23 January 2018

Department of Planning & Environment
Resource Assessments
GPO Box 39
Sydney NSW 2001

BOBS FARM SAND MINE PROJECT – SSD 6395 – NELSON BAY ROAD (MR108), BOBS FARM

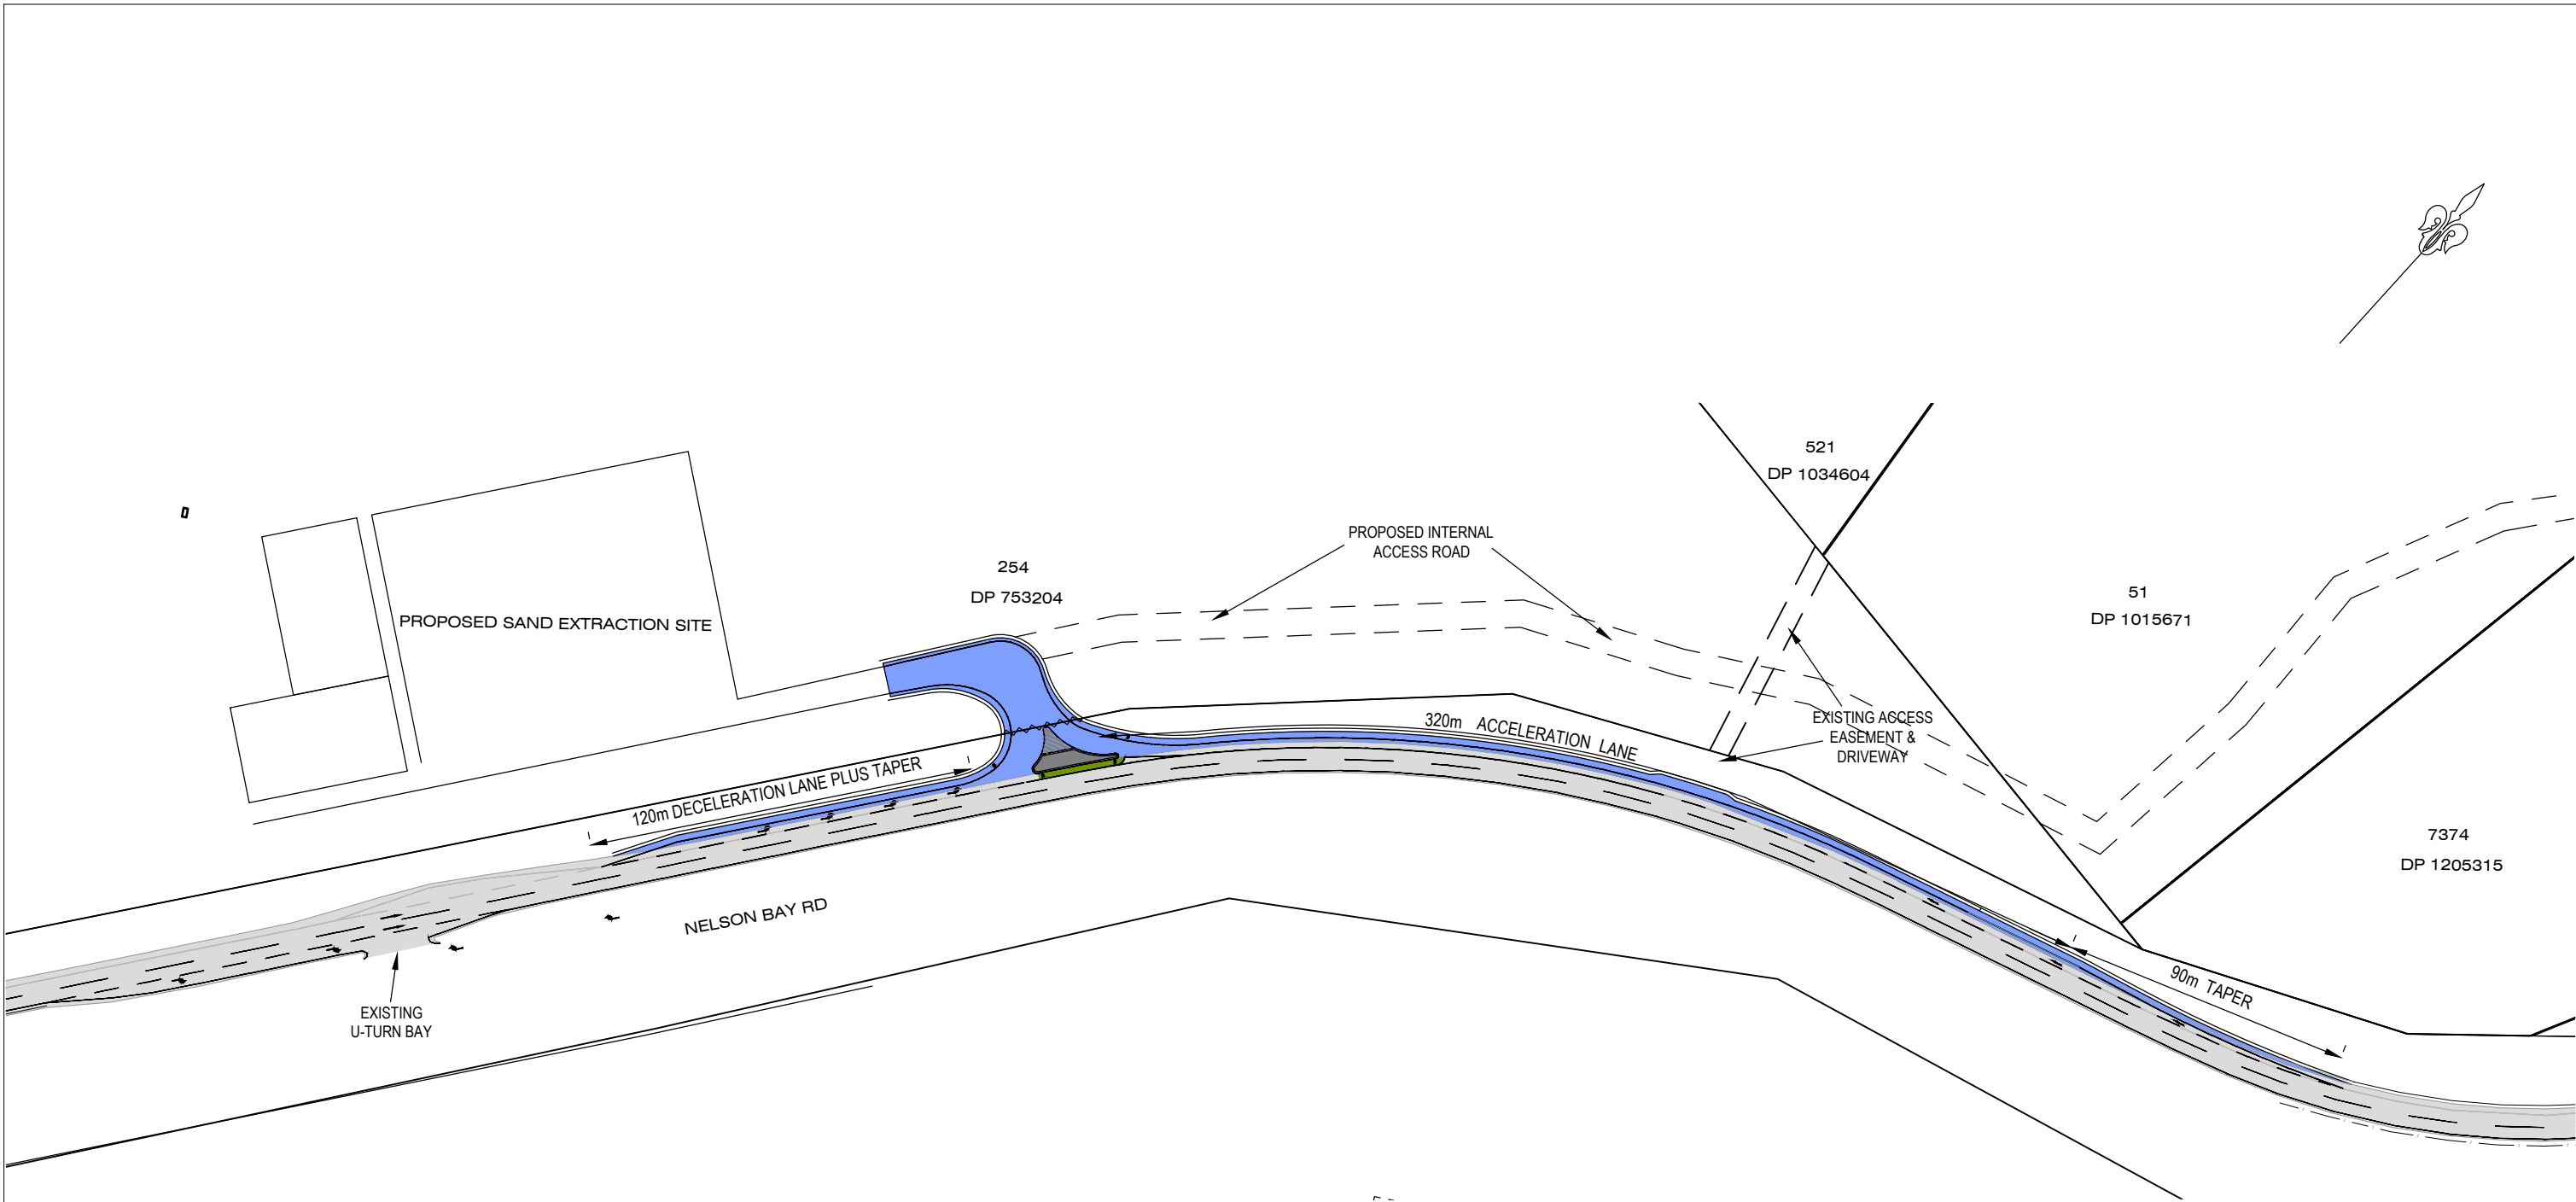
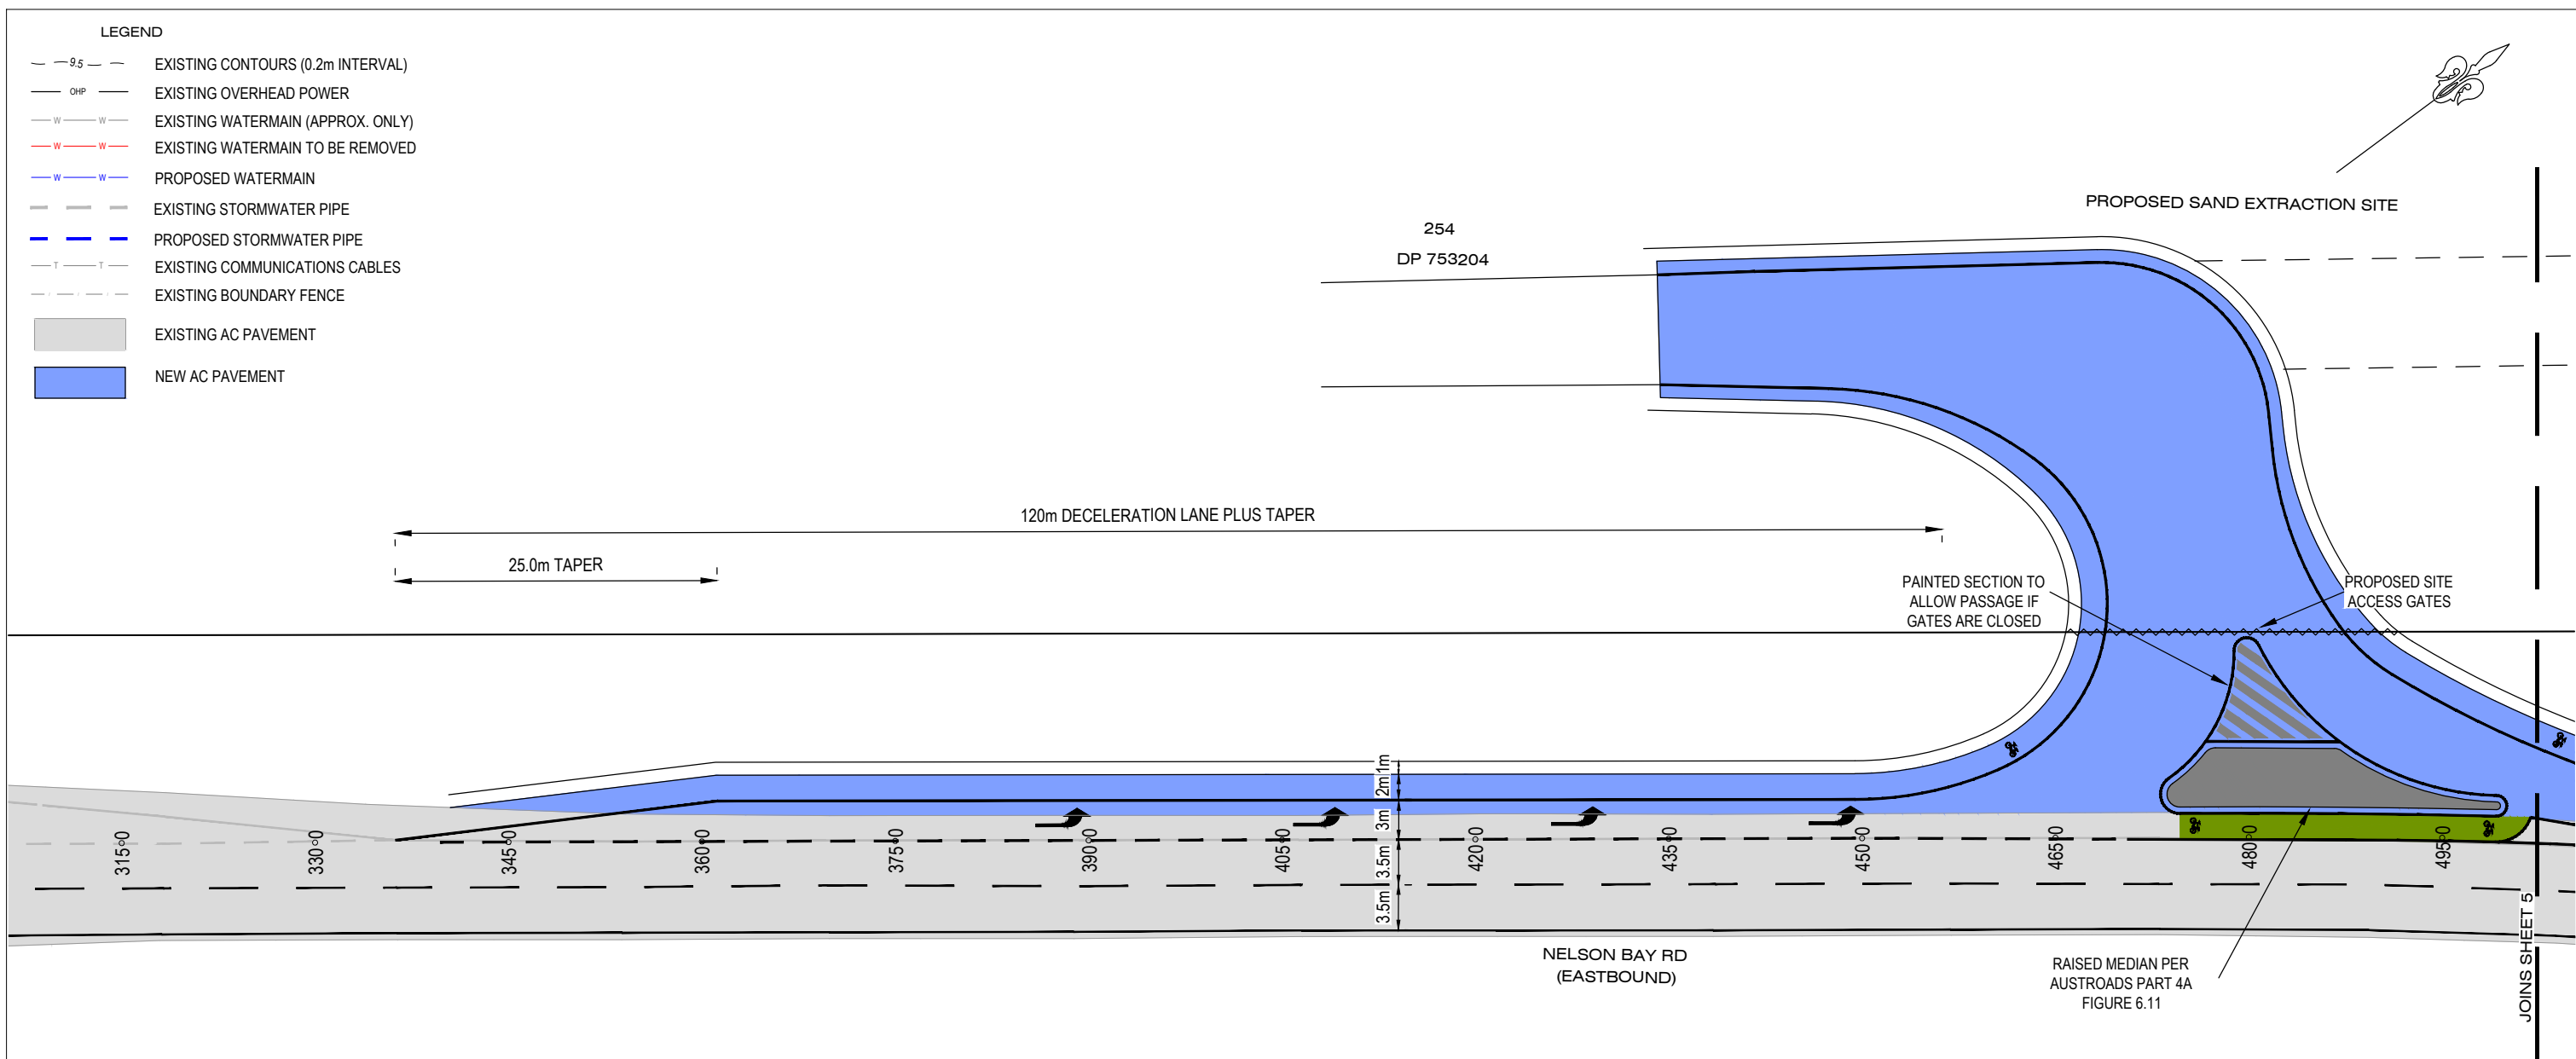
- Roads and Maritime note that access is proposed for heavy vehicles into the site from Nelson Bay Road. Roads and Maritime raise no objection to an access being provided from Nelson Bay Road, subject to a deceleration lane being provided in accordance with Austroads guidelines, and Roads and Maritime satisfaction. The works are required to be completed prior to commencement of and construction or operations on the site.
